September 13, 2021
Scott McGee PE
9700 Sand Verbena Trail, NE
Albuquerque, NM 87122

**Re: Element Hotel - 2440 Louisiana Blvd., NE
Erosion and Sediment Control Plan
Engineer's Stamp Date 9/2/21 (H19E087)**

ESC PLAN

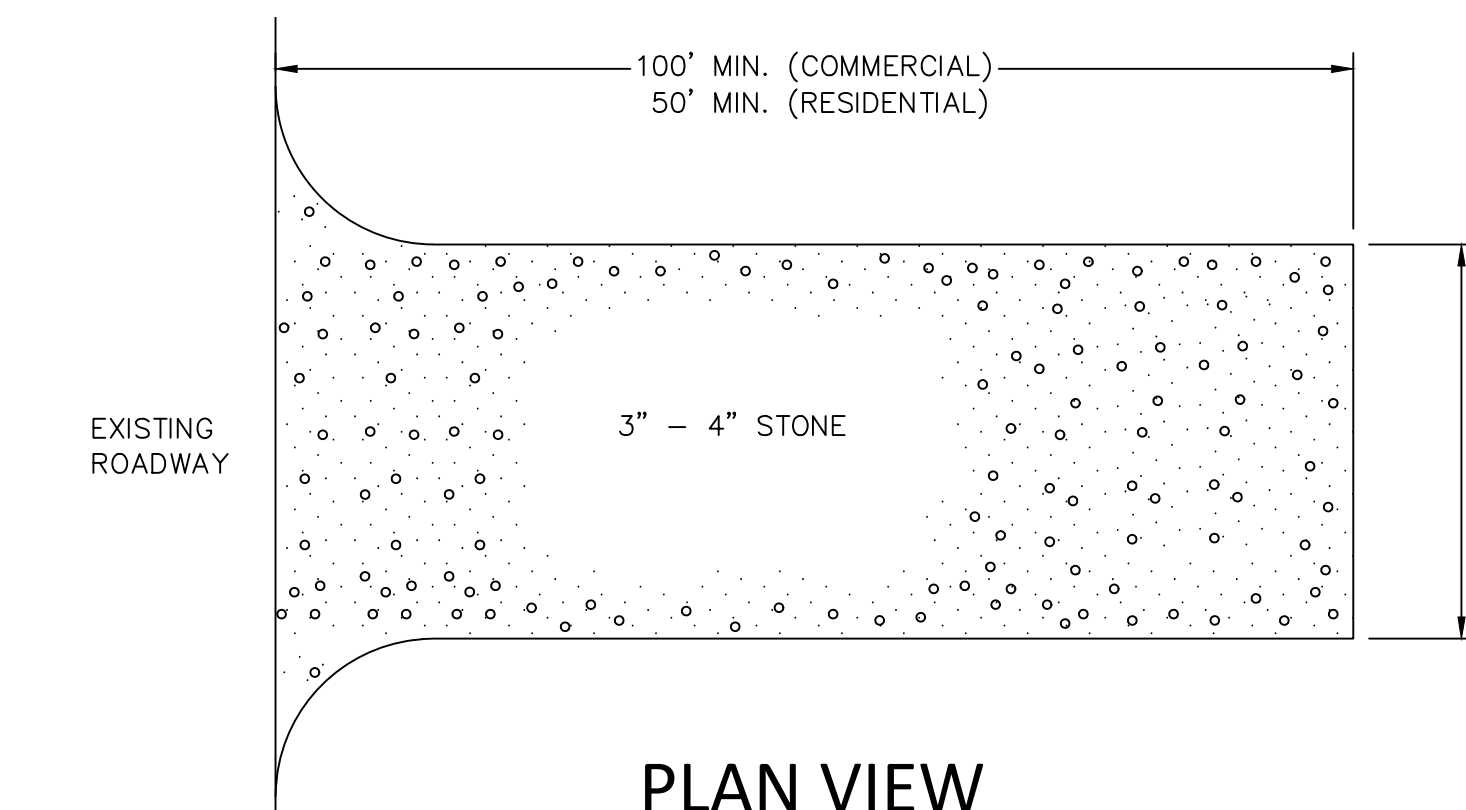
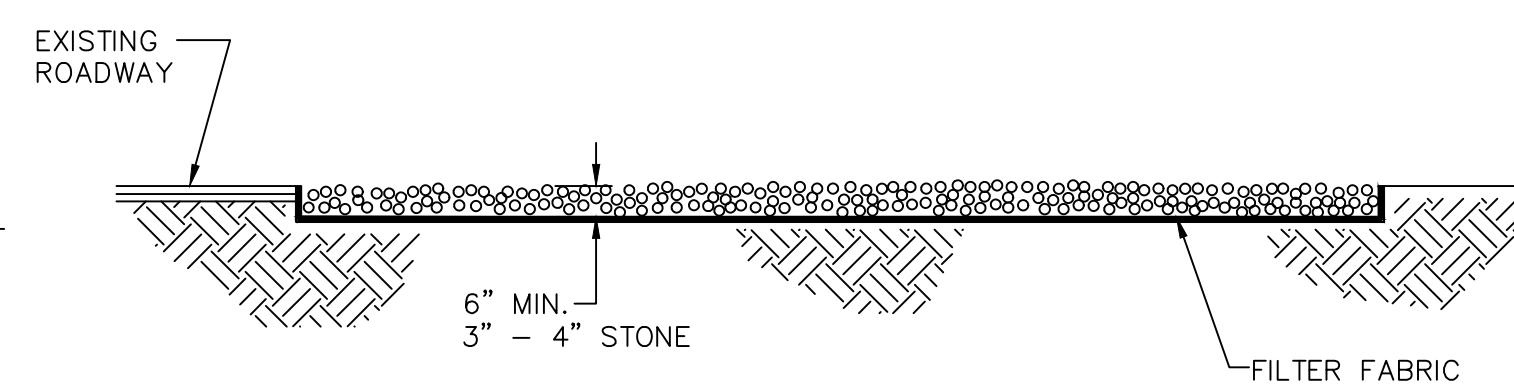
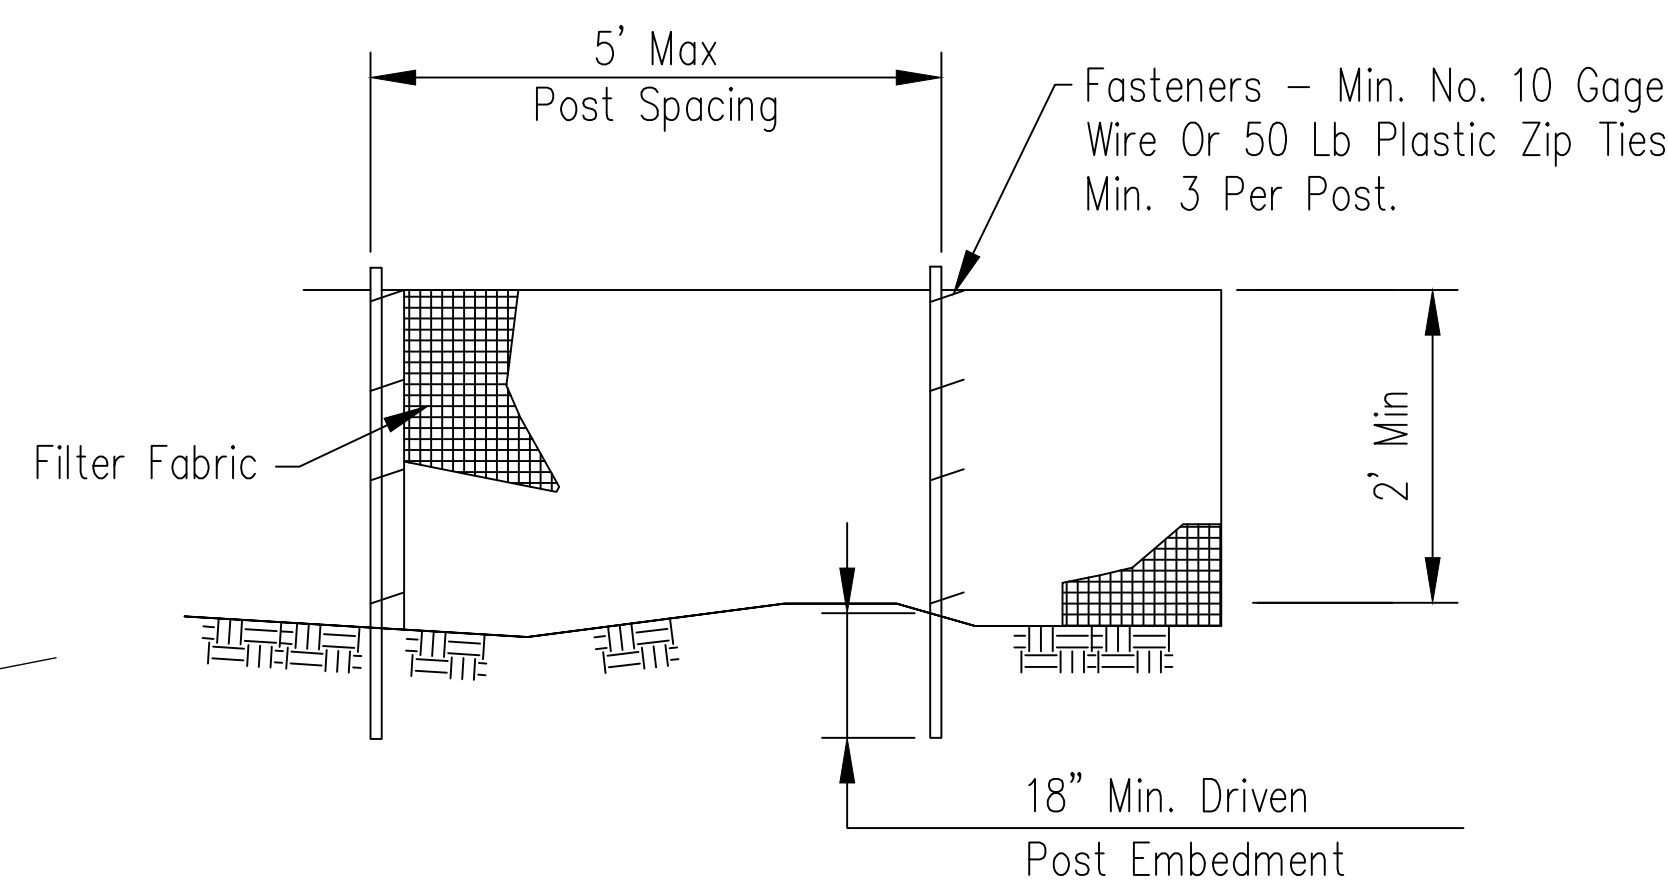
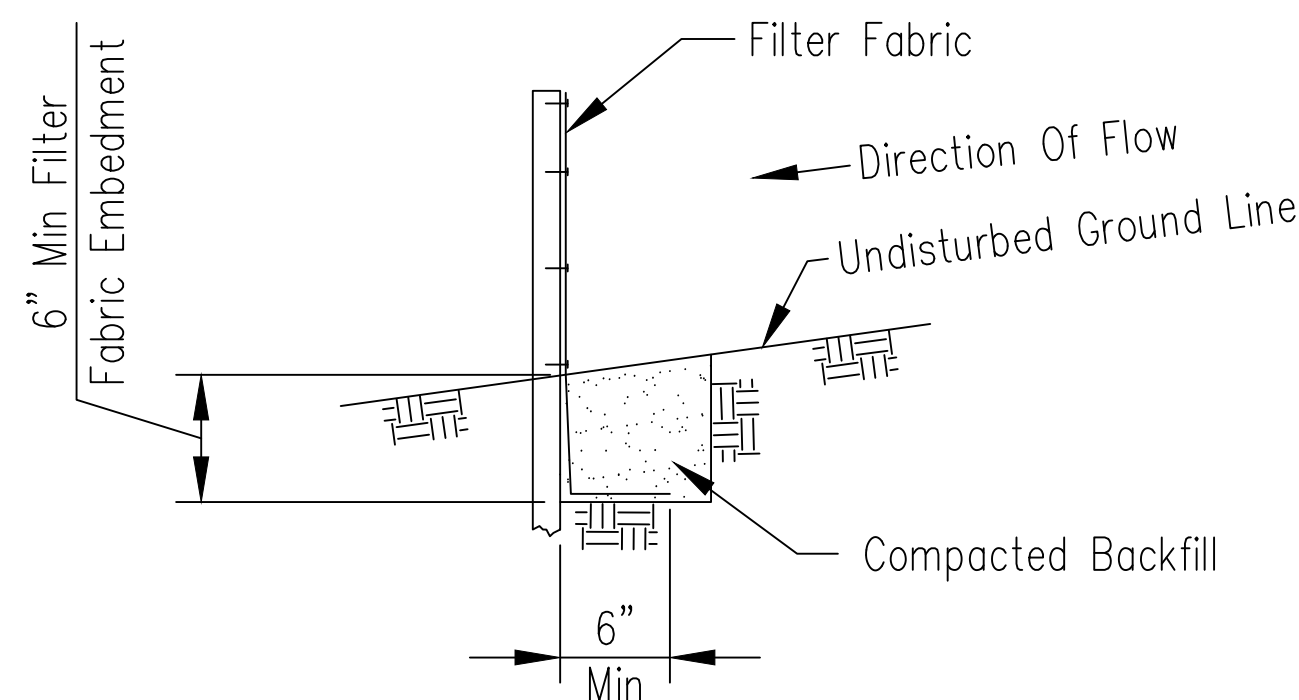
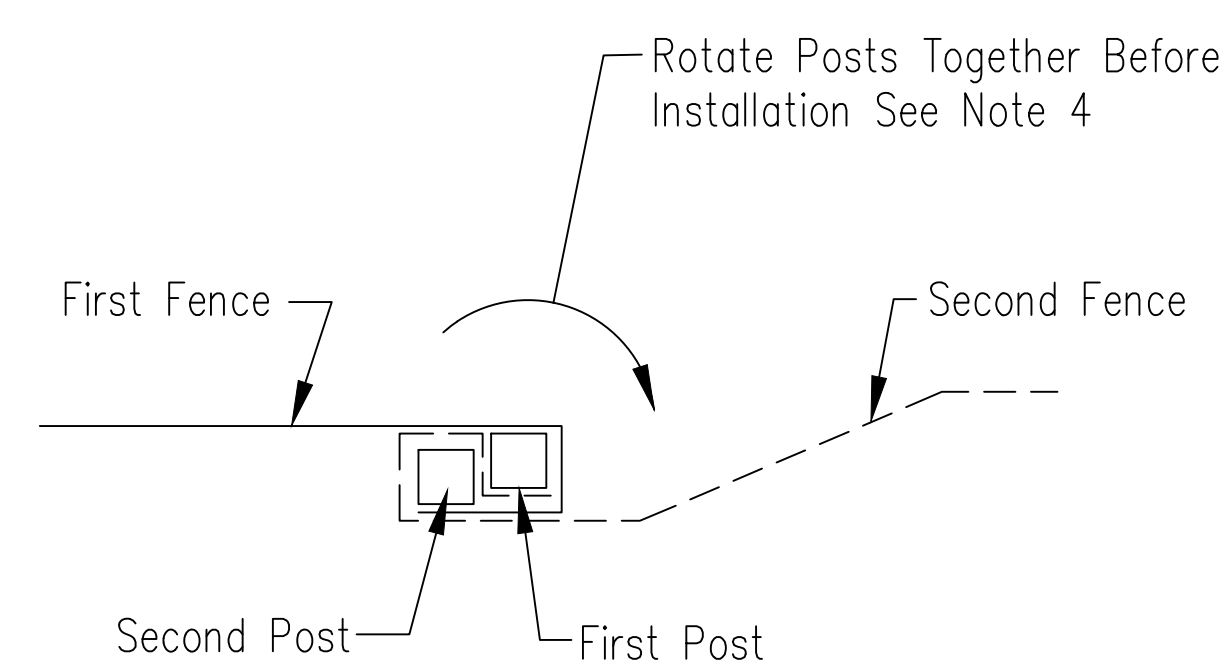
1. Add a legend to the plan and show the location of the silt fence, inlet protection, and NPDES posting.
2. Show the drainage patterns. Identify locations where sheet flow enters and exits the site.
3. The area of disturbance is larger than the property. Identify both the lot area and the total area of land-disturbing activities.
4. Add a projected schedule or sequence of construction beginning and ending with the BMPs. Include posting NPDES coverage, demolition, grading, storm drain construction, BMPs for the storm drain (inlet protection), paving, and landscaping.
5. The ESC Plan can't be approved for Grading or Work Order until the property owner's NOI has been reviewed and approved by City Stormwater Quality.
6. Update the engineer's stamp date each time the plan is changed.
